<b>Application Ref:</b>	3/2026/0048			 <b>Ribble Valley Borough Council</b> <small>www.ribblevalley.gov.uk</small>				
<b>Date Inspected:</b>	03/03/26	<b>Site Notice:</b>	03/03/26					
<b>Officer:</b>	LW							
<b>DELEGATED ITEM FILE REPORT:</b>					<b>APPROVAL</b>

<b>Development Description:</b>	Proposed replacement stables.
<b>Site Address/Location:</b>	The Barn, Old Langho Road, Langho, BB6 8AW.

Drawing Title		
Proposed Ground floor plan and elevations		
Scale	Date	Drawn
1:100 @ A3	Nov 2025	JC

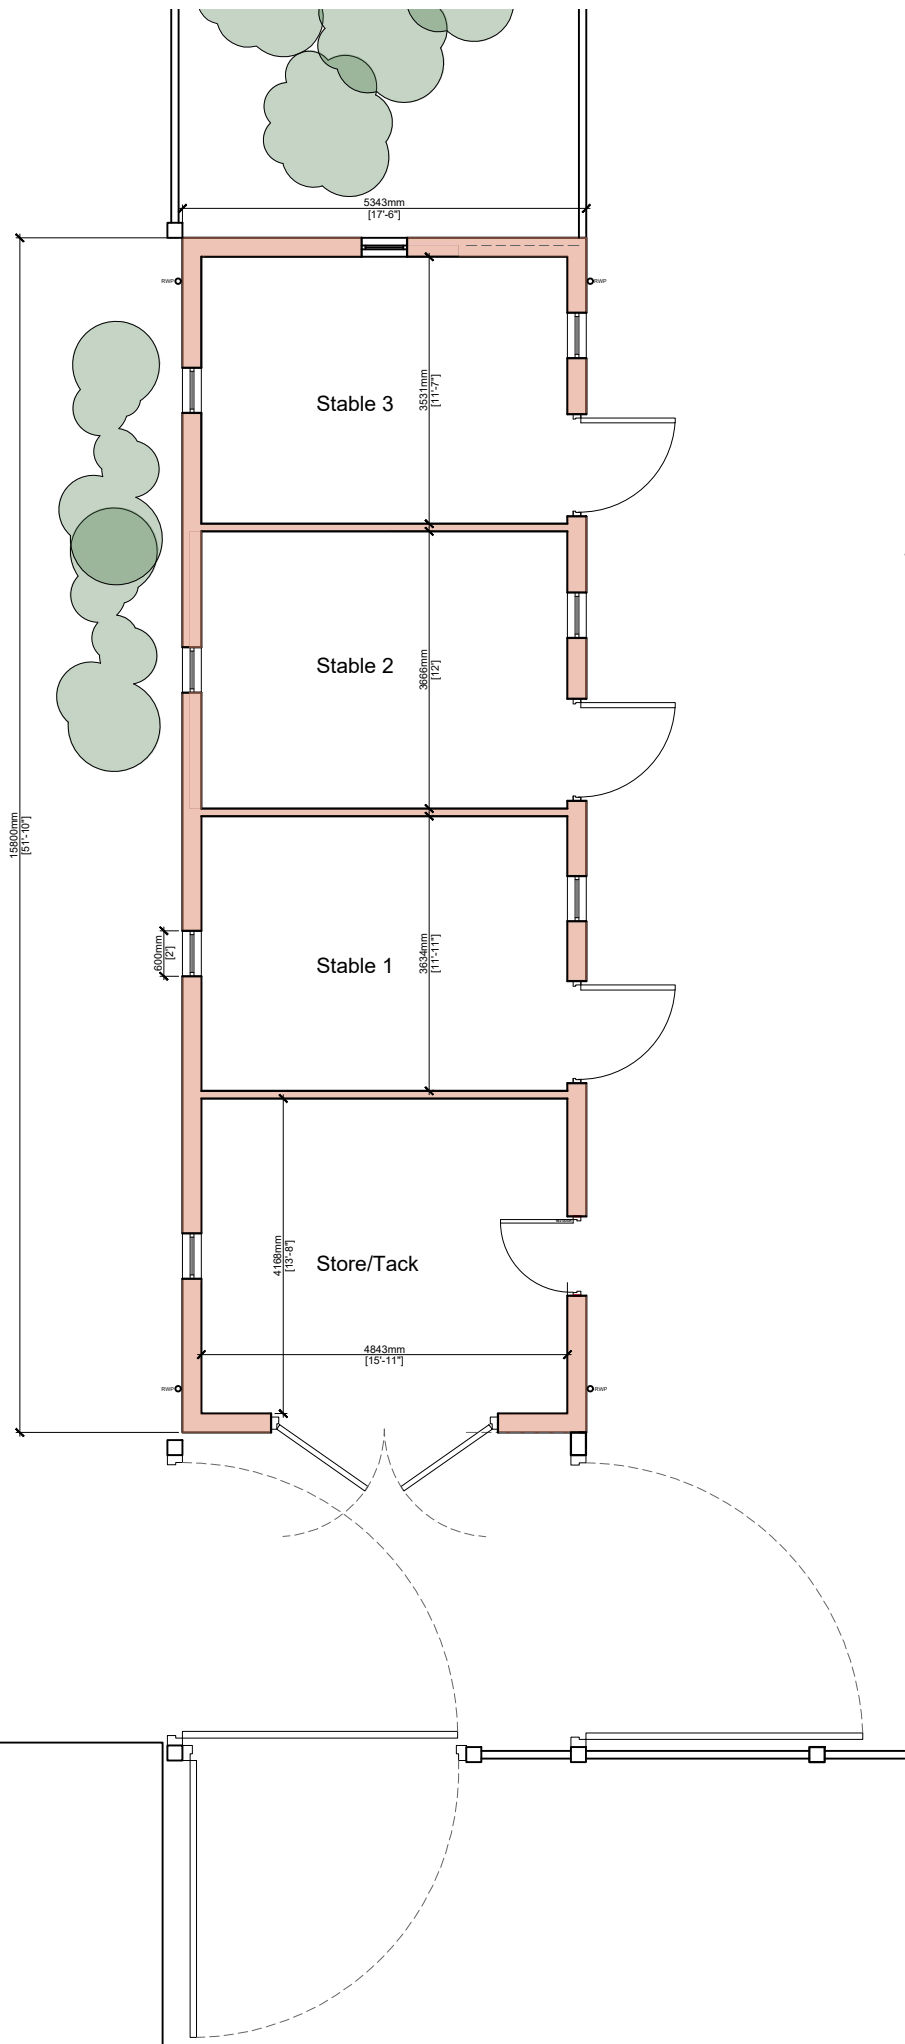
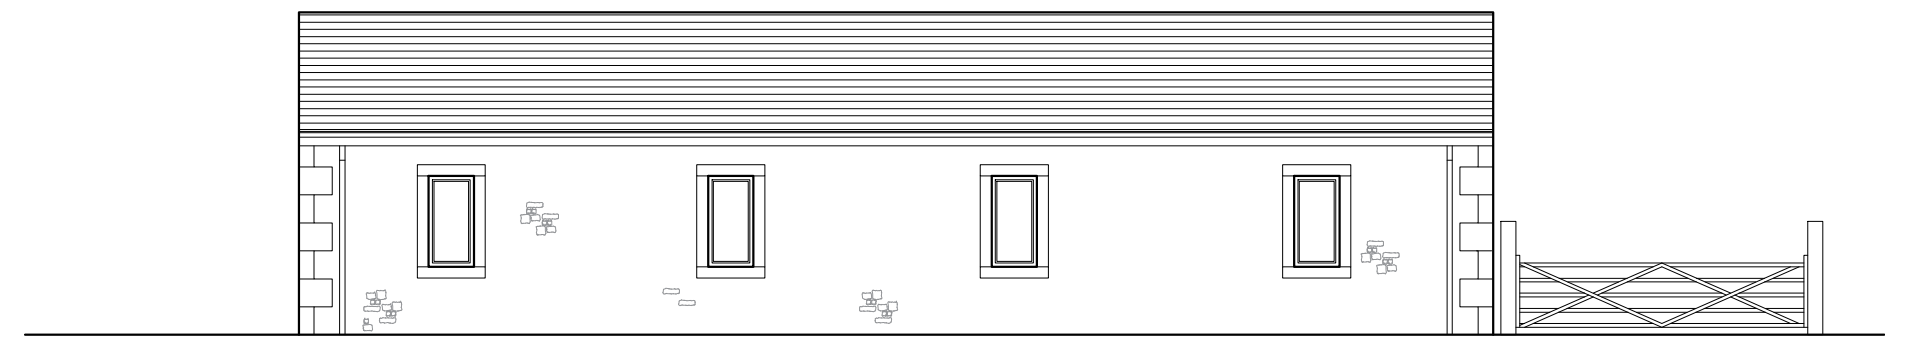
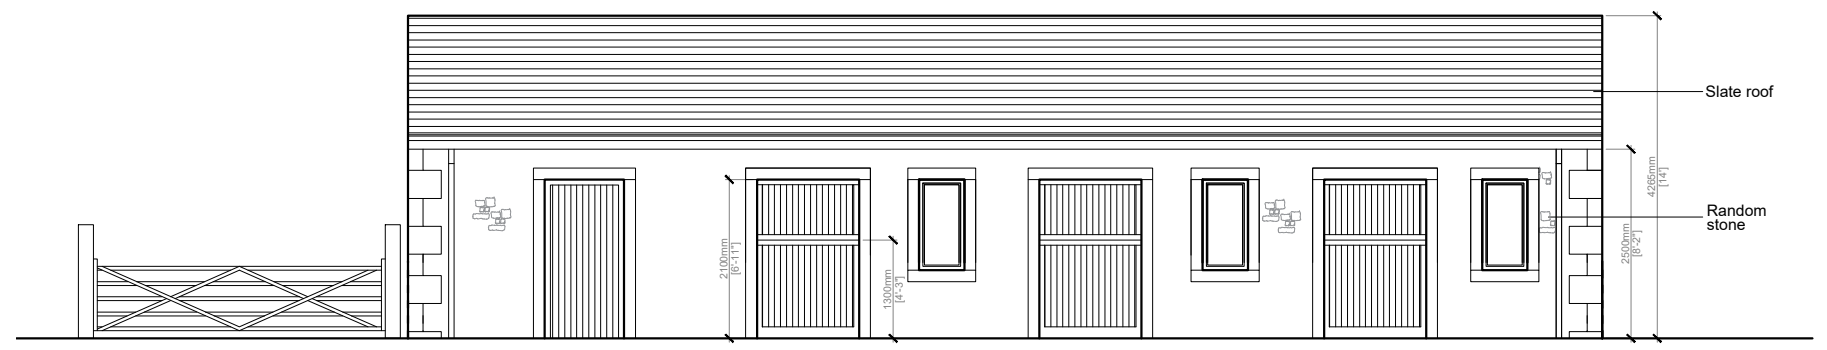
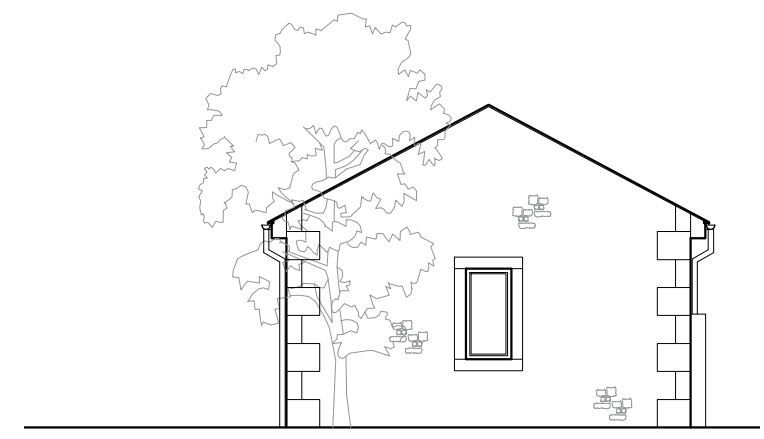
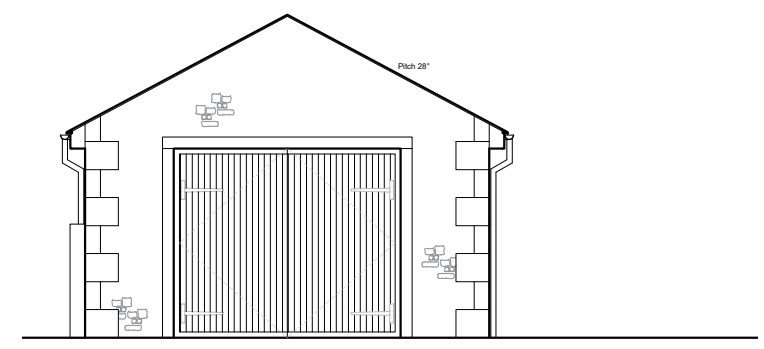
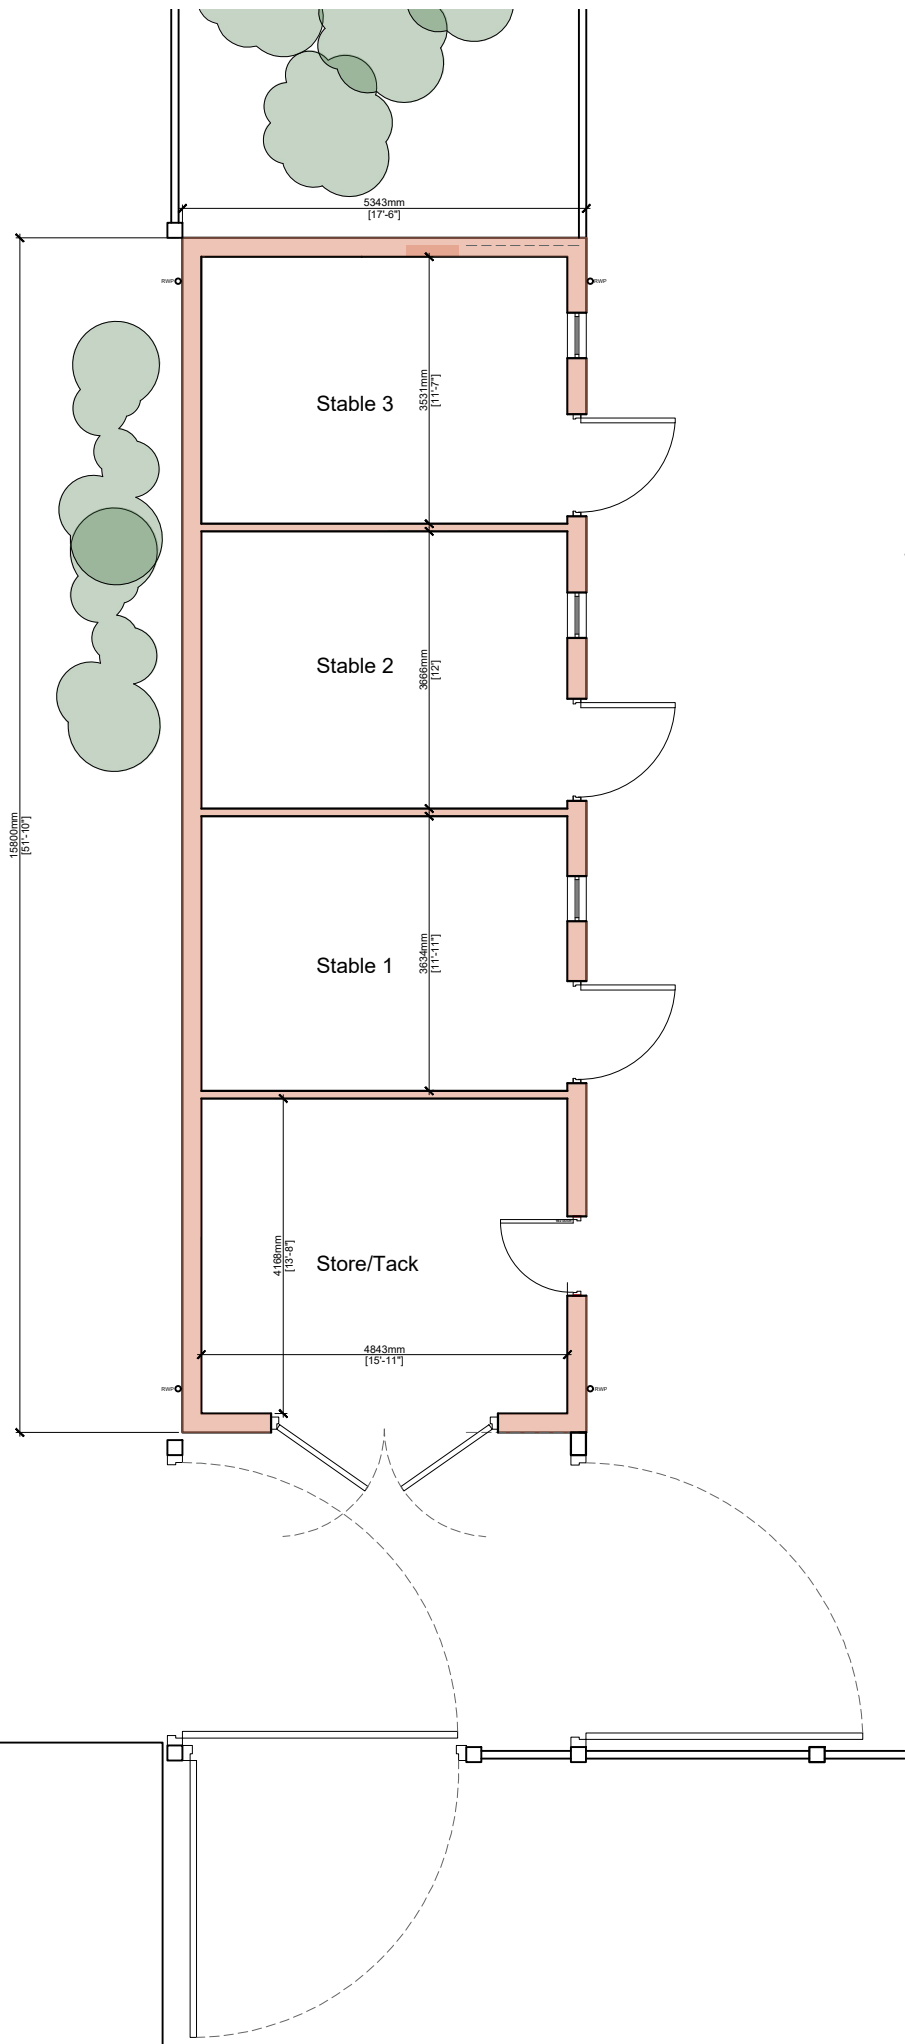
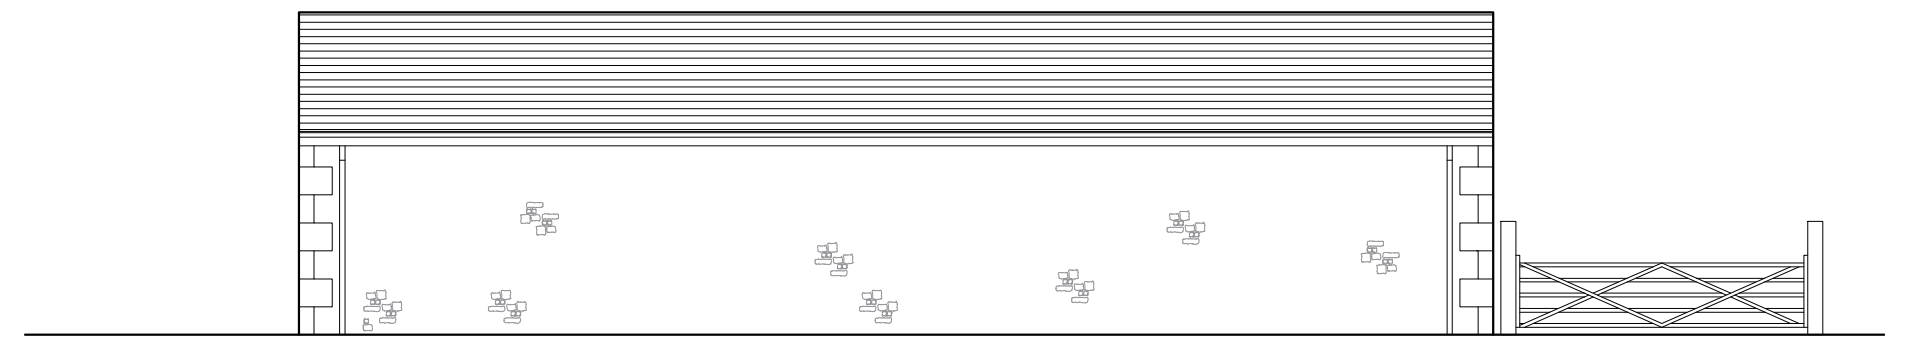
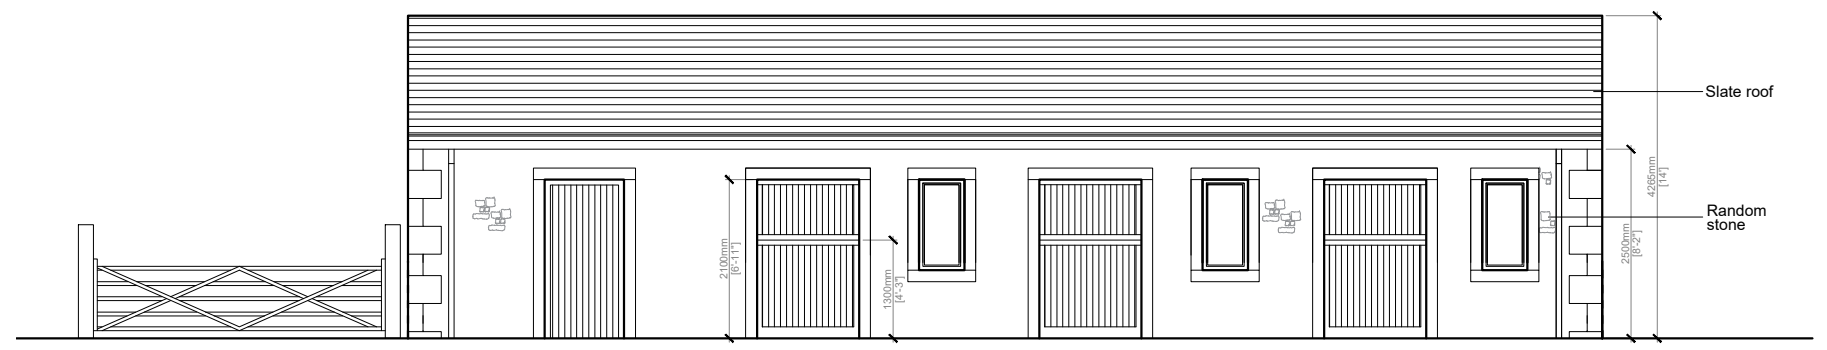
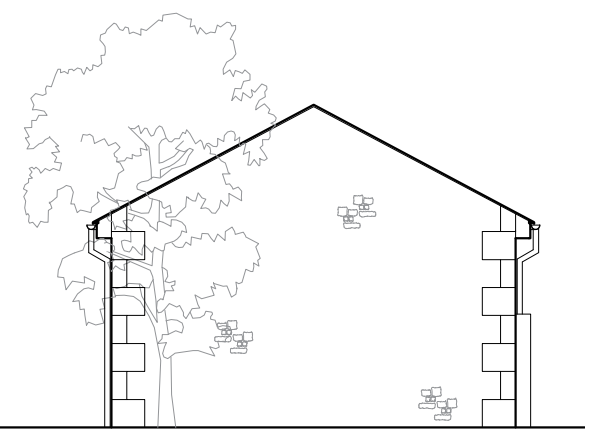
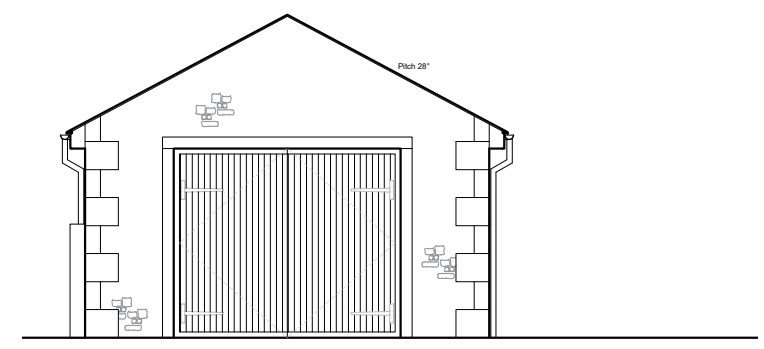
The scheme originally submitted with the application including a number of additional openings to the north-western and north-eastern facing elevations. However, this was considered excessive in relation to the building's proposed use as a stable block. The removal of these openings is considered to be an improvement from the originally proposed scheme.

The proposed plans have been amended prior to the determination of this application, with the originally proposed window openings to the north-western and north-eastern facing elevations removed in an attempt to improve the overall design of the stable block and ensure that it appears appropriate for its intended use.
